Comments on REP6-030 -Permanent Sealing of land page 27

1.1 Applicant's reply

1.2 Comments in response

Annex C Drainage Strategy General Arrangement

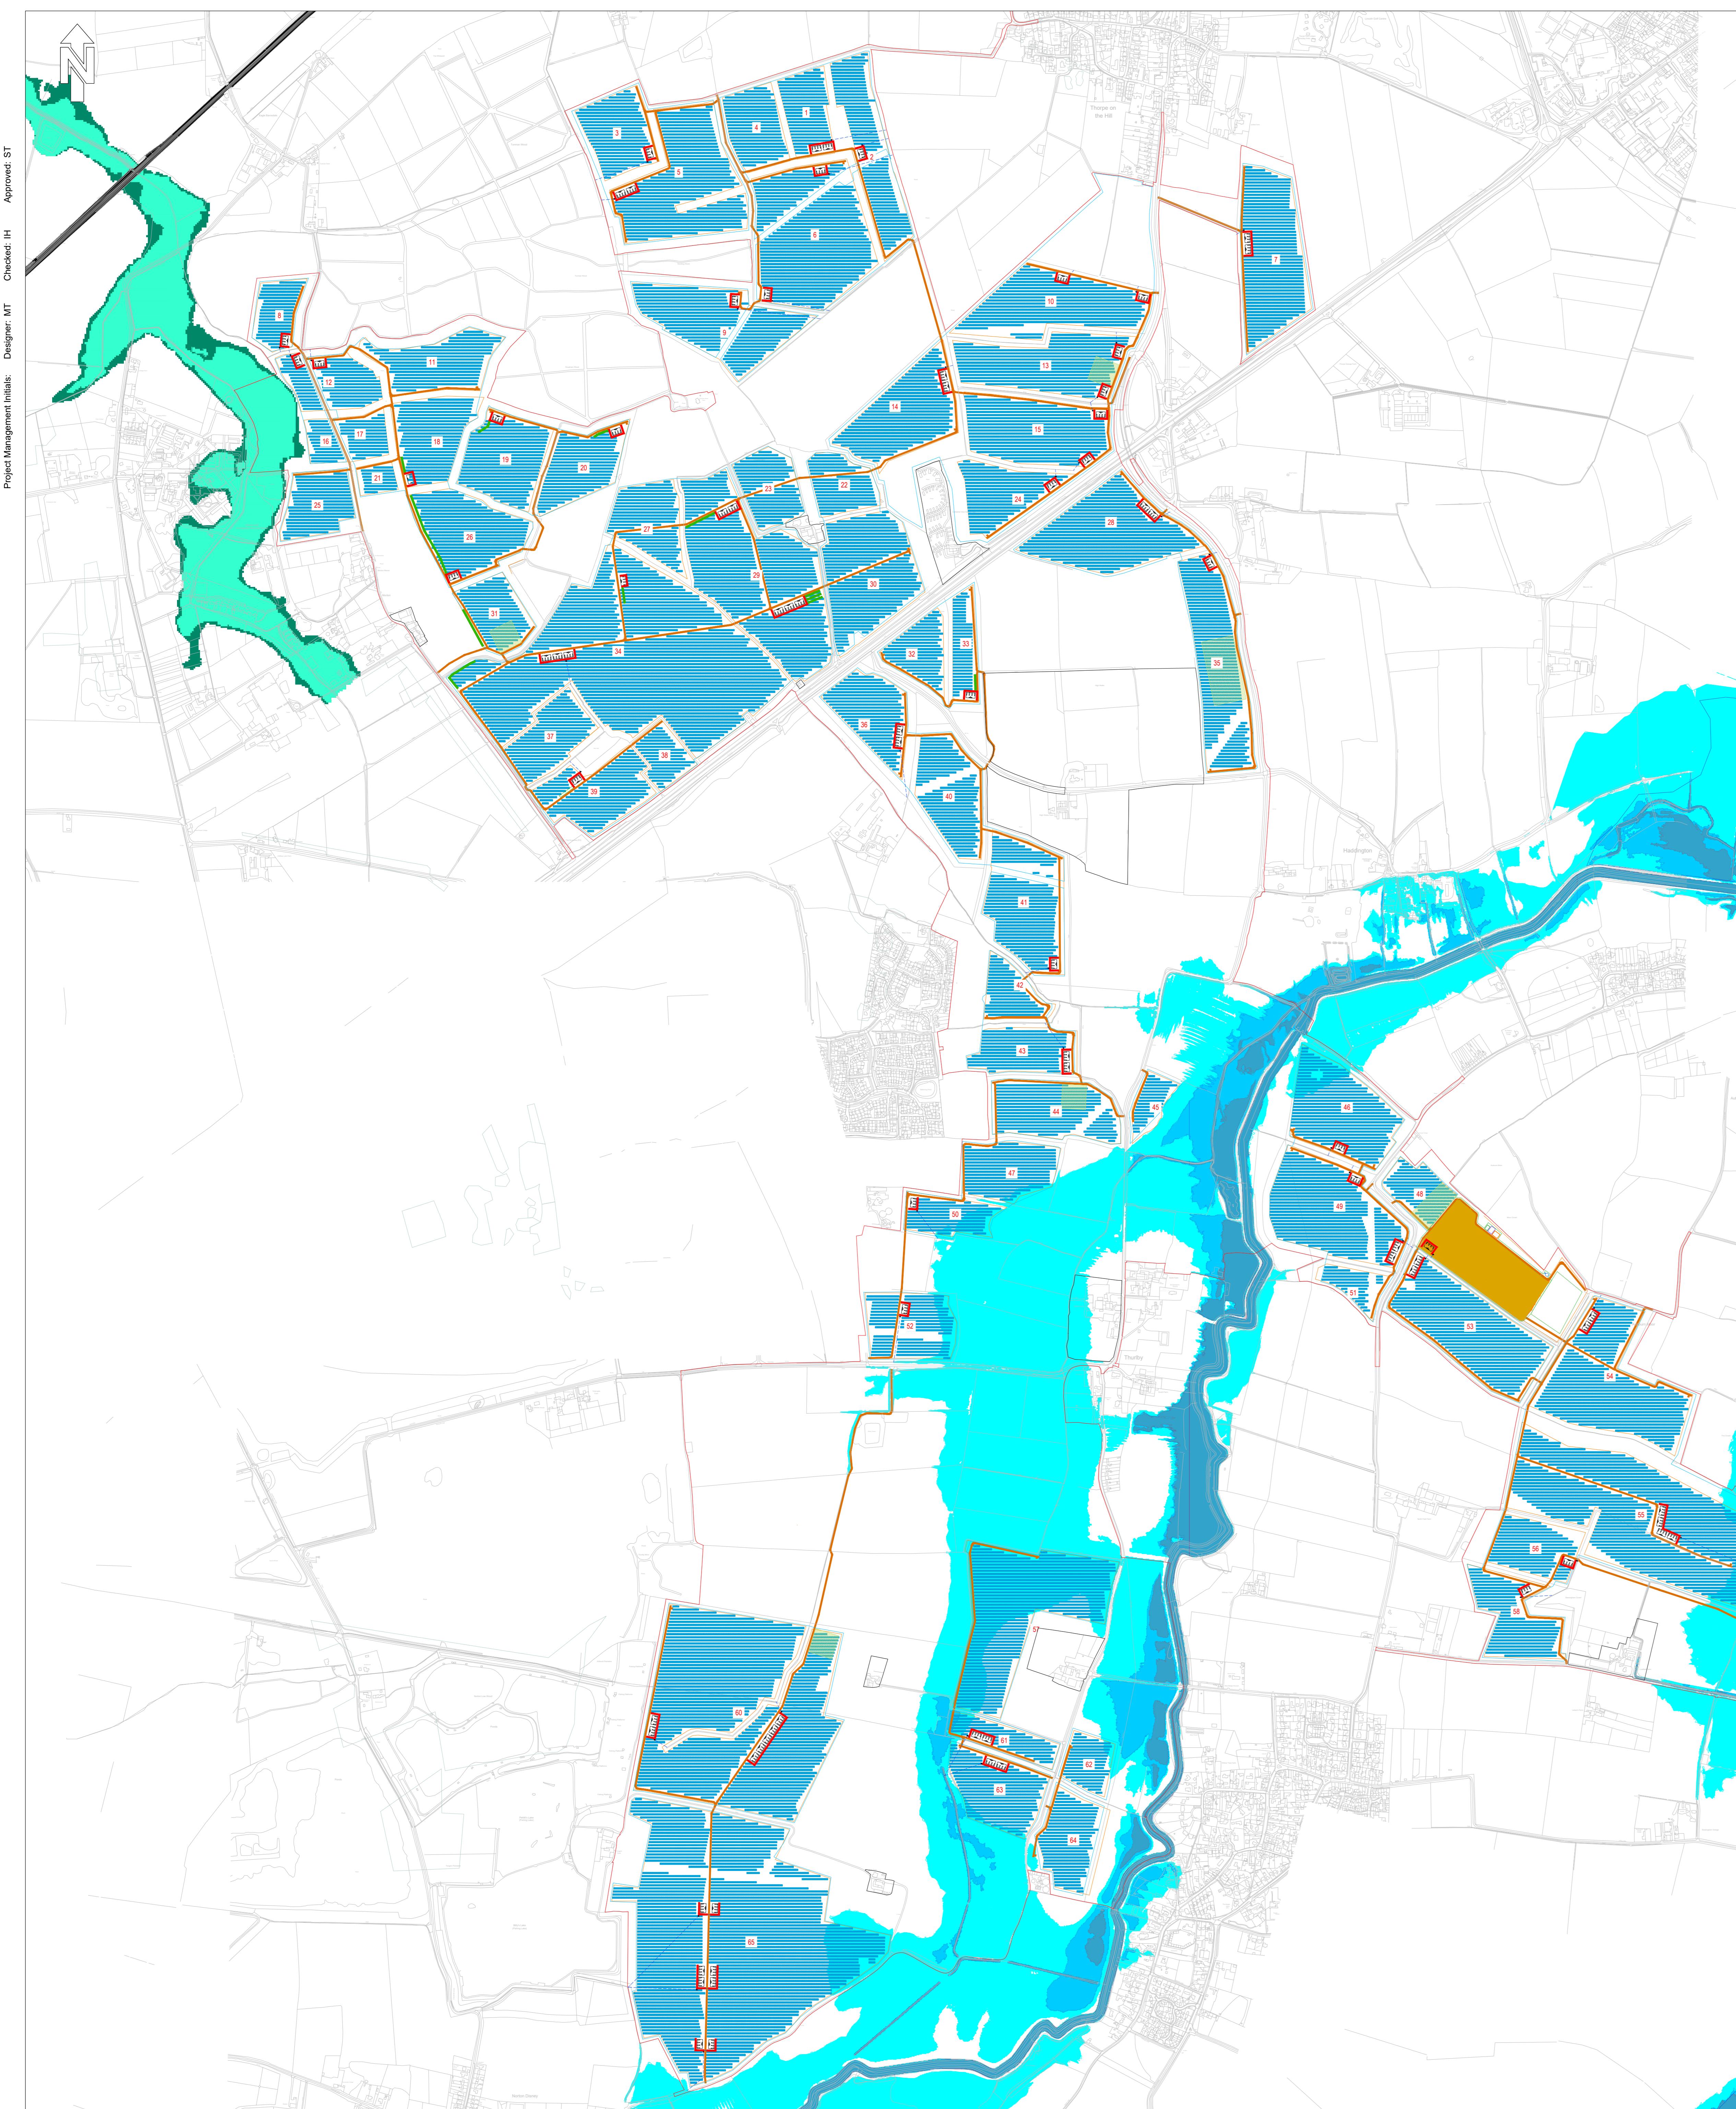
- The impermeable swales constructed on three sides of each of the 100 Solar Station Compounds as set out in the Framework Surface Water Drainage Strategy (REP3-014) and illustrated on the plan at Annex C to the strategy. The swales will be 6m wide, the total area across the principal site has not been stated. There will also be a lined impermeable sustainable drainage system and attenuation swale in connection with the centralised BESS (paragraph 4.5.5 of the FBSMP (REP6-020).

The Applicant has not confirmed the total area of land including the swales that potentially could be deemed to be sealed over nor the ALC grading of this land.
